Your Ref :
Our Ref : P/91/17/NMA

Application for a non- material amendment following the grant of P/125/14/PL relating to approved plans.

251 Pagham Road, Pagham, ,

FOR
CRAYFERN HOMES LIMITED
Scale : 1:100 @ A1 Date : AUG 17
Drawing No : 108_16 SK06

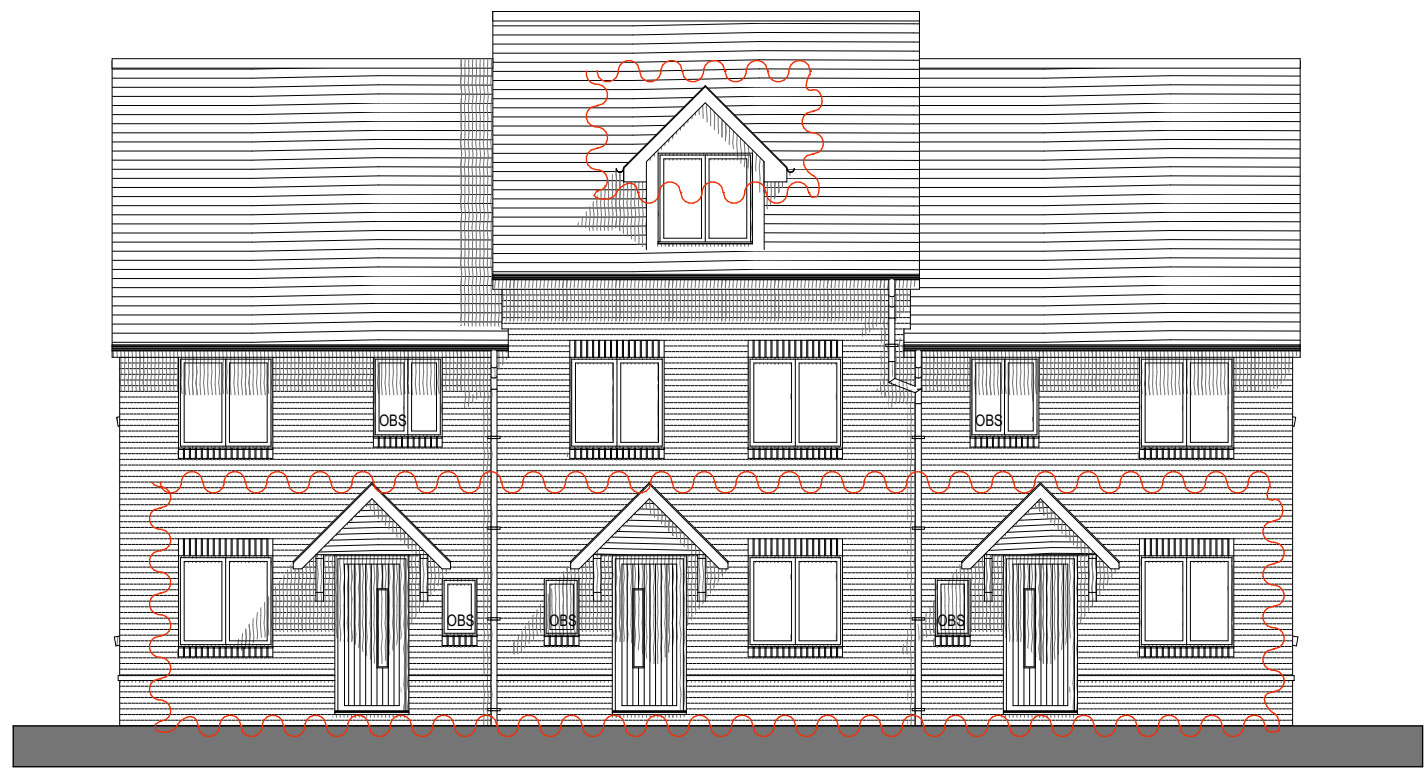
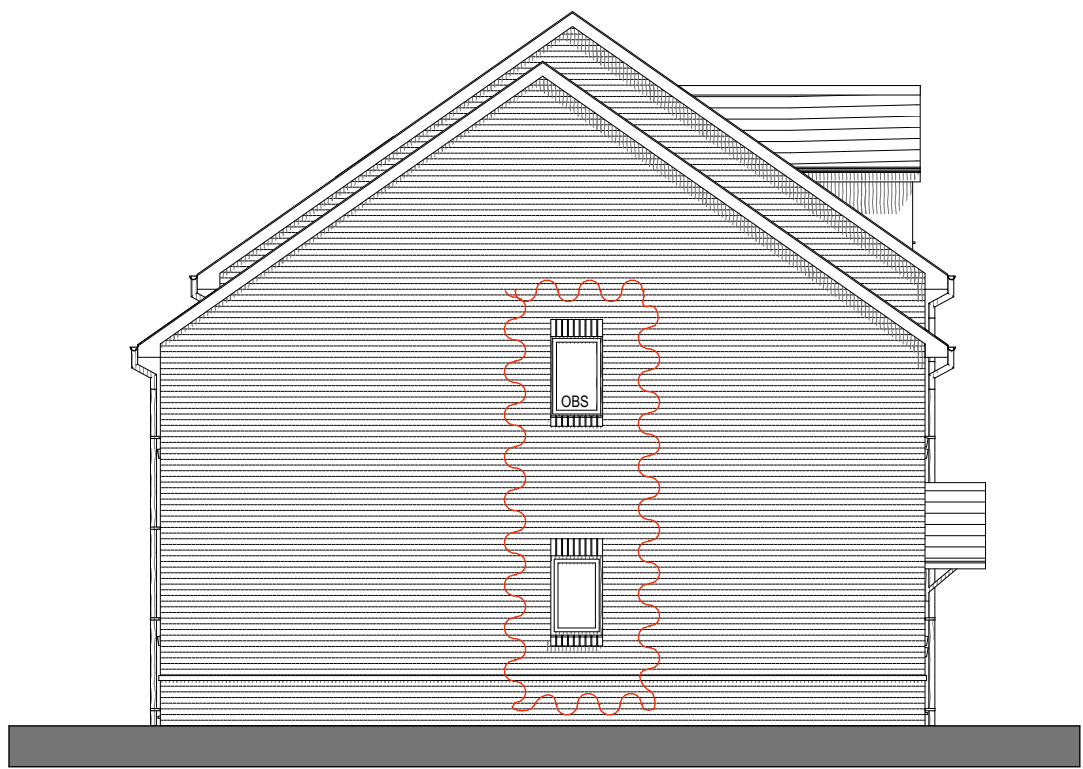
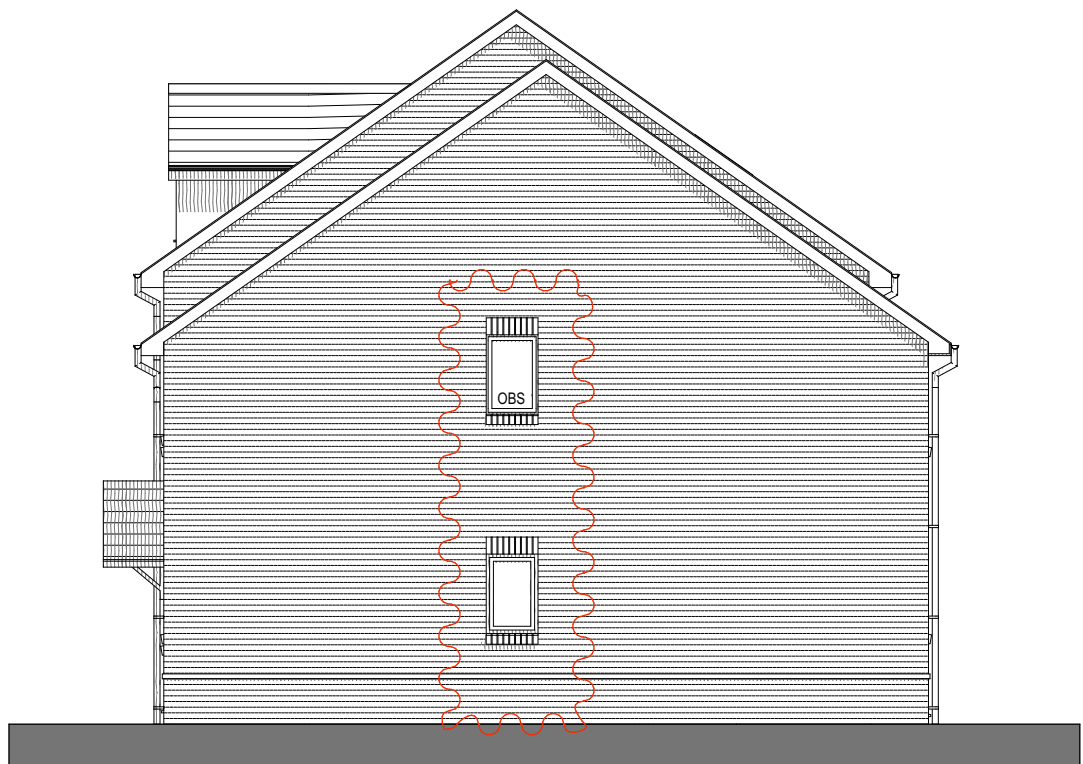
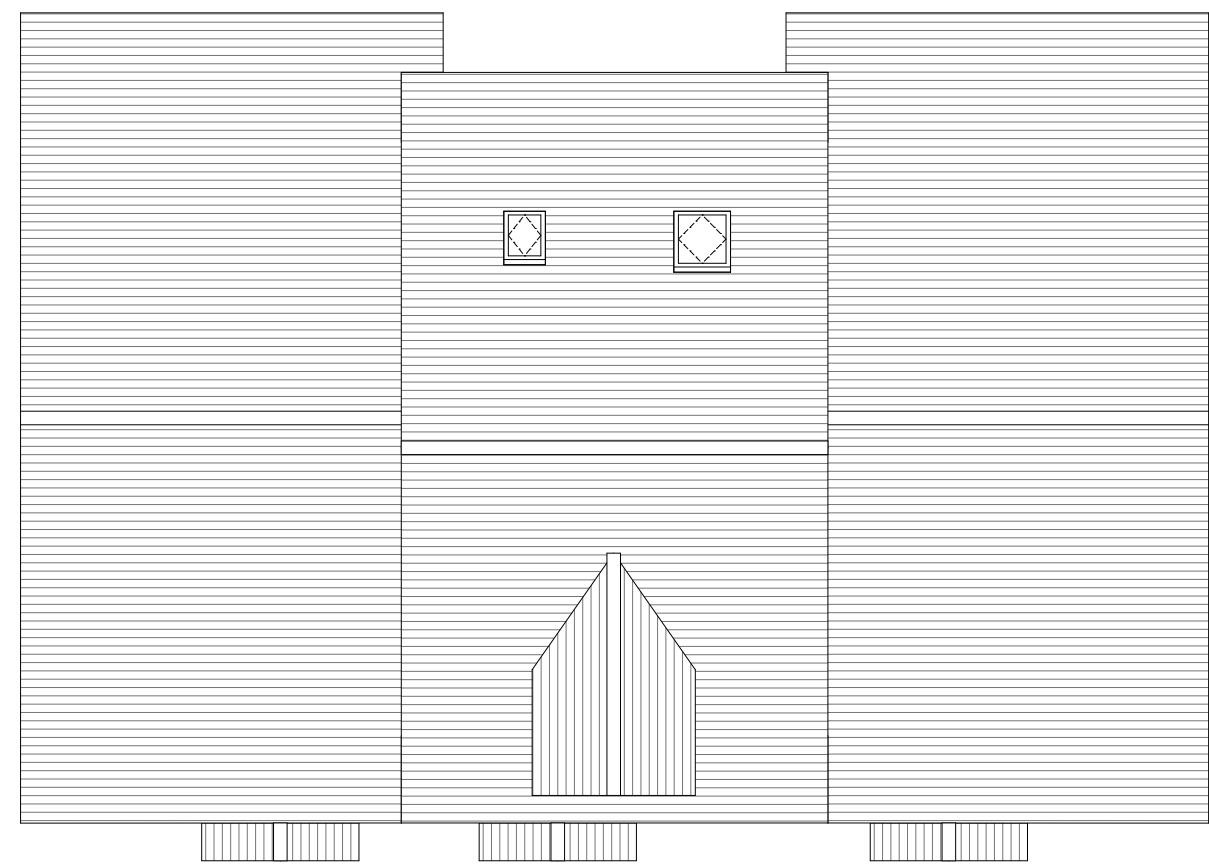
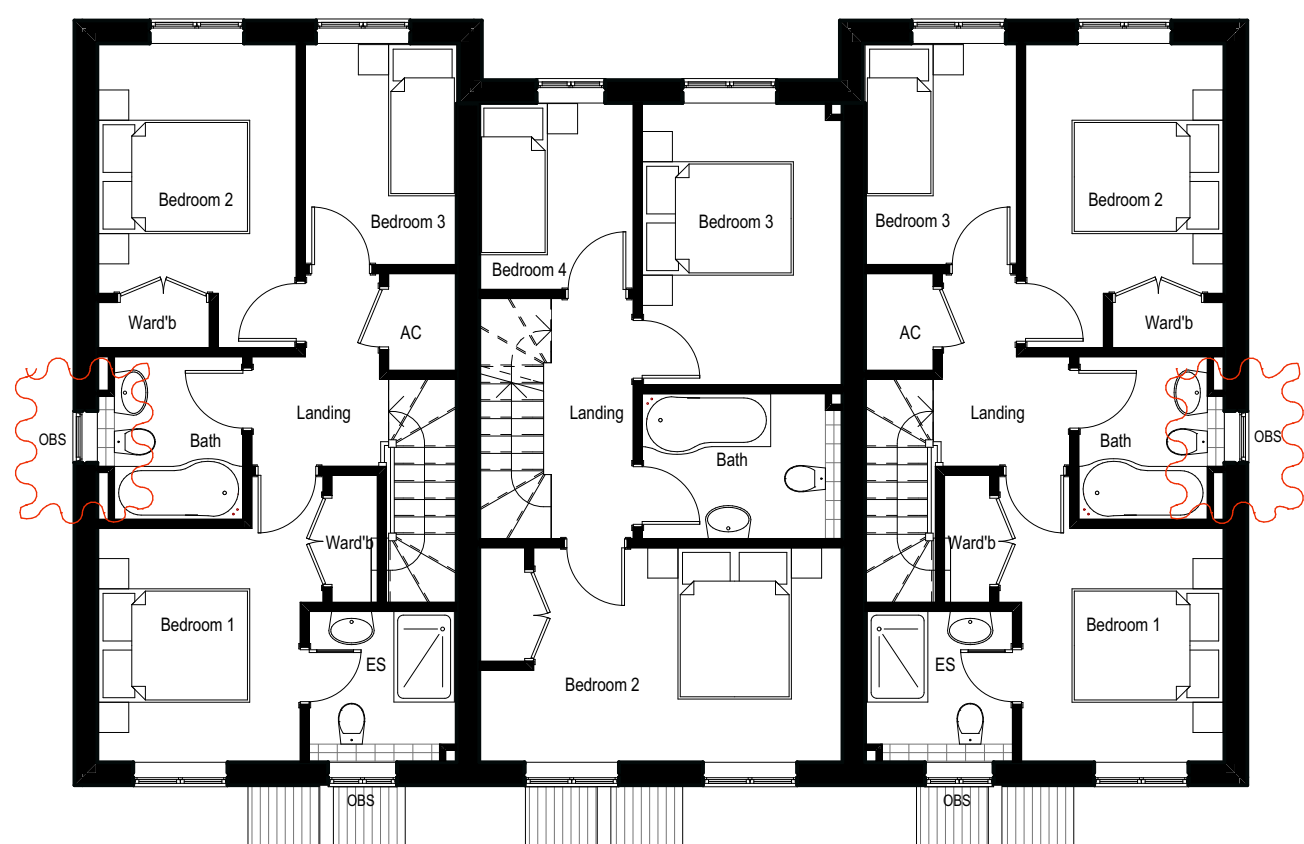
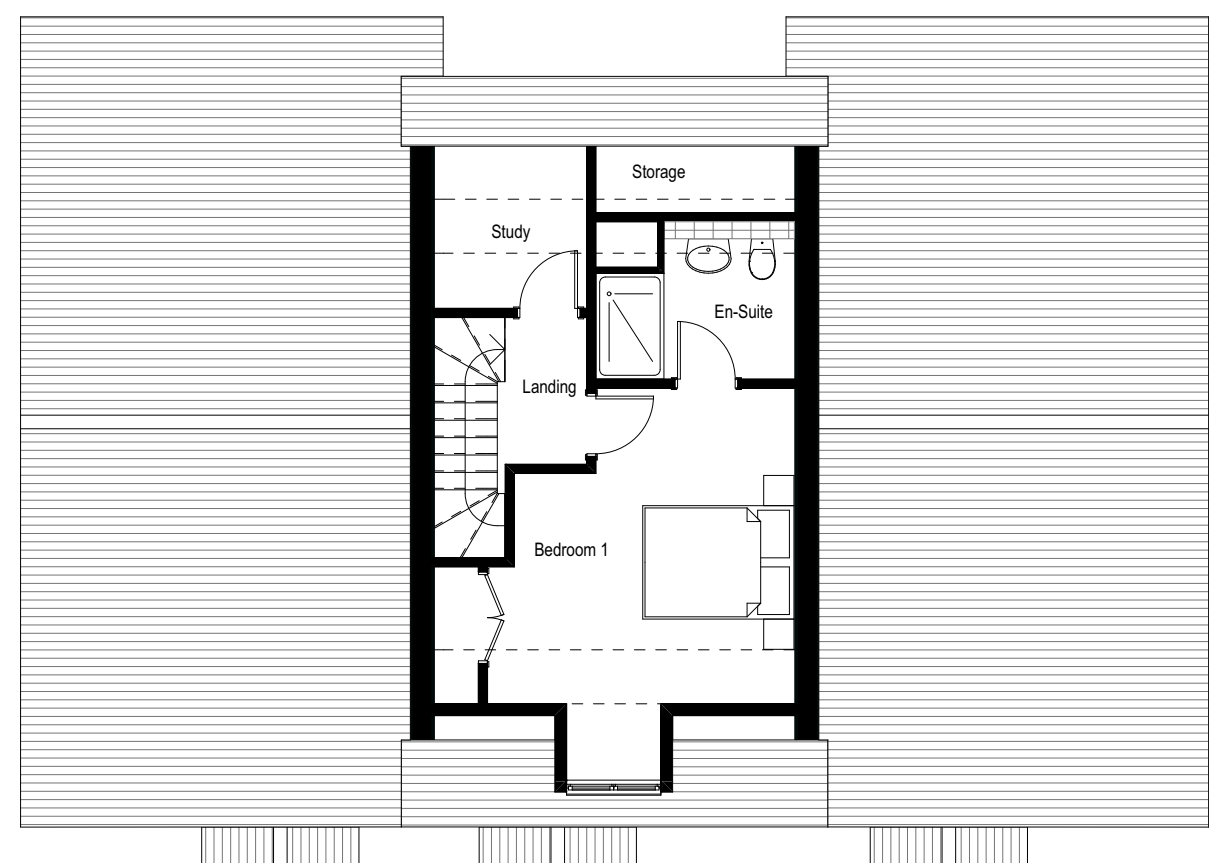
Plots 12-14 - Alterations to the design of first floor rear windows, alterations to the design of the ground & first floor windows to both side elevations, alterations to the design of the ground floor front windows & doors and alterations to the design of the roof level front single dormer;
